Application No: FG/82/21/PL
Site Address: 11 Ferring Marine Ferring BN12 5PP
Description of works: Variation of condition imposed under FG/127/19/HH relating to approved plans.

Thank you for your internet representation made on 4th June 2021 which has been recorded as an objection with the comments as follows:

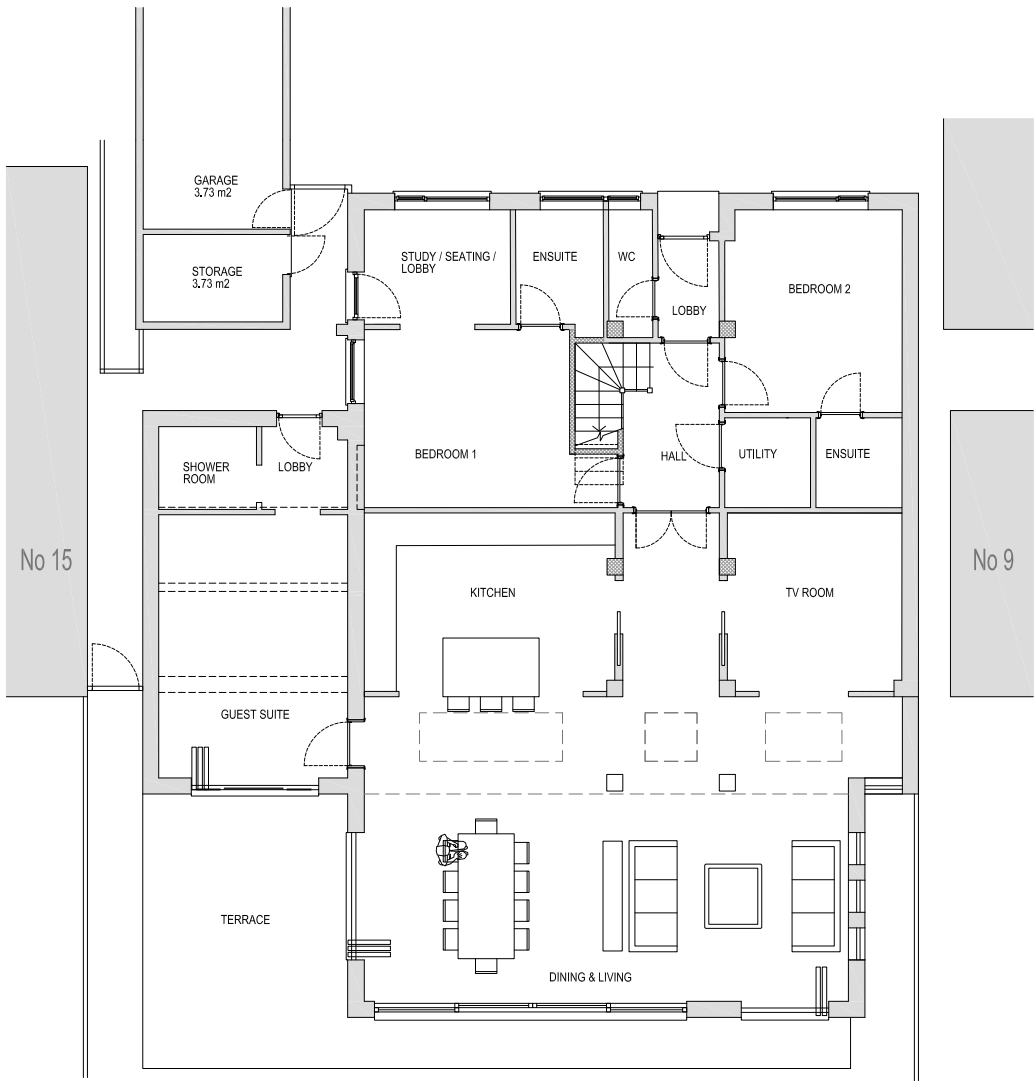
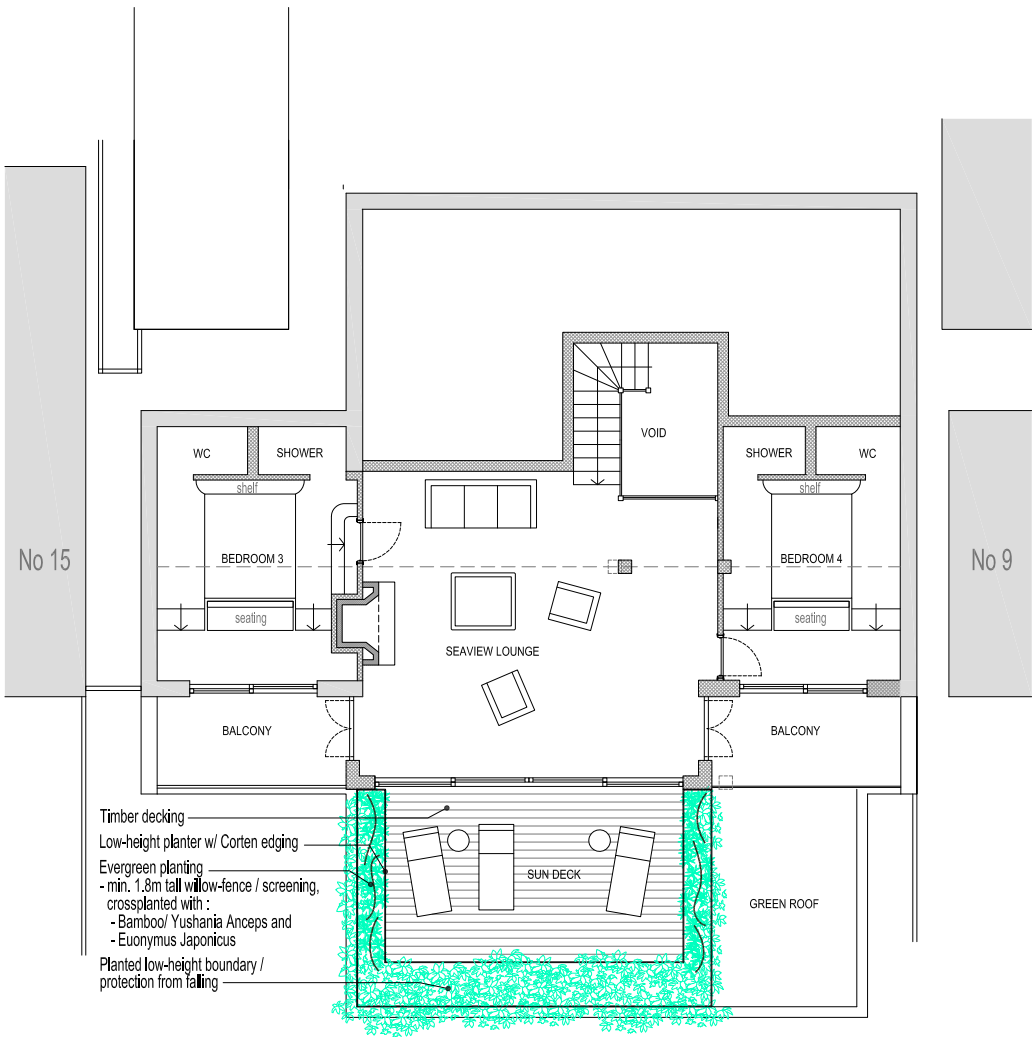
The owner has already flagrantly violated many of his approved plans, and these violations show he has no regard for the local area and, in combination with the balcony he has already built, show he cannot be trusted to keep the balcony to the proportions shown in the current plans. His current installation of wooden decking violates the current requirement for a green roof and even violates this amendment he has submitted by covering the entire ground floor extension in wooden decking, rather than the central section shown in his current planning submission which should have an accompanying green roof he has left no room for (i.e. he

has already built more than he is now seeking permission for, and all of this before any permission has been granted). In addition, his planning application notice has not even been placed outside his house, but outside his neighbour's house.

PROPOSED
ELEVATIONS AND
MAIN SECTION

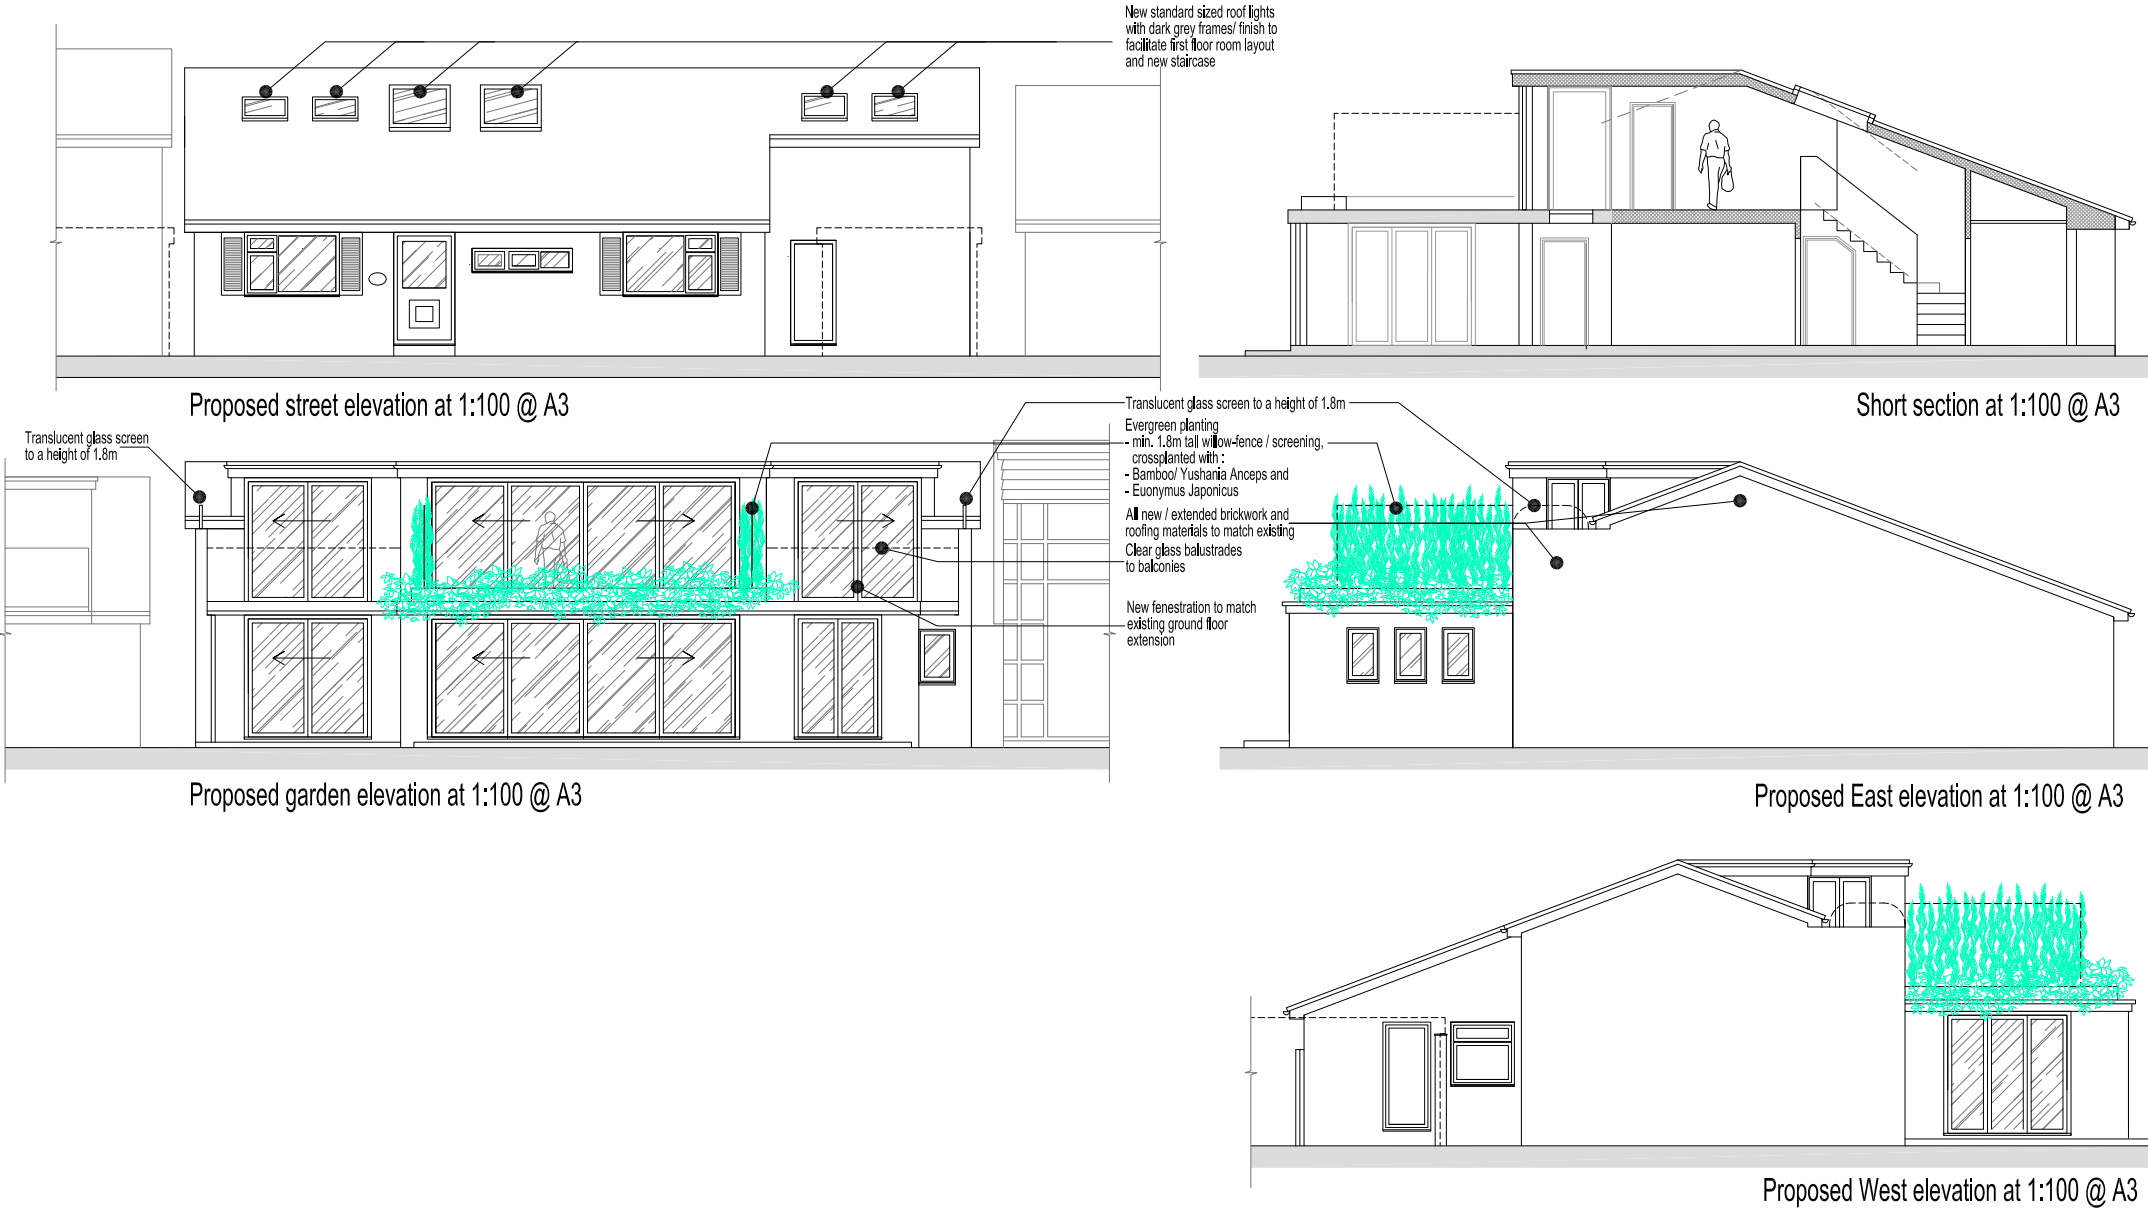
The already current extension has resulted in around 50% of my garden losing sunlight by just 4pm (just before I get home from work ready to enjoy my garden). I have forgone going to work and stayed at home for the last two days to take a photo showing this, but sadly cloud cover means this hasn't possible. Instead I have attached (Fig. 1) a sketch showing how the current extension blocks sunlight from half my garden. I declare that to my best knowledge this is an accurate representation of the current state of sunlight he has already blocked. Adding a 1.8m high privacy screen to the sides of his proposed new balcony will take nearly all of the sunlight from my garden, as shown in the attached sketch.

While the neighbour is sunning himself on his monstrous sundeck, me and my 4 year old boy will be forced to play in the shadows of our garden.

This will almost destroy my house for me and my little boy. I work during the day so my only time to enjoy the garden is in the summer evenings, but by 4-5pm the privacy screen will block nearly all our sunlight making it cold, dark and unpleasant.
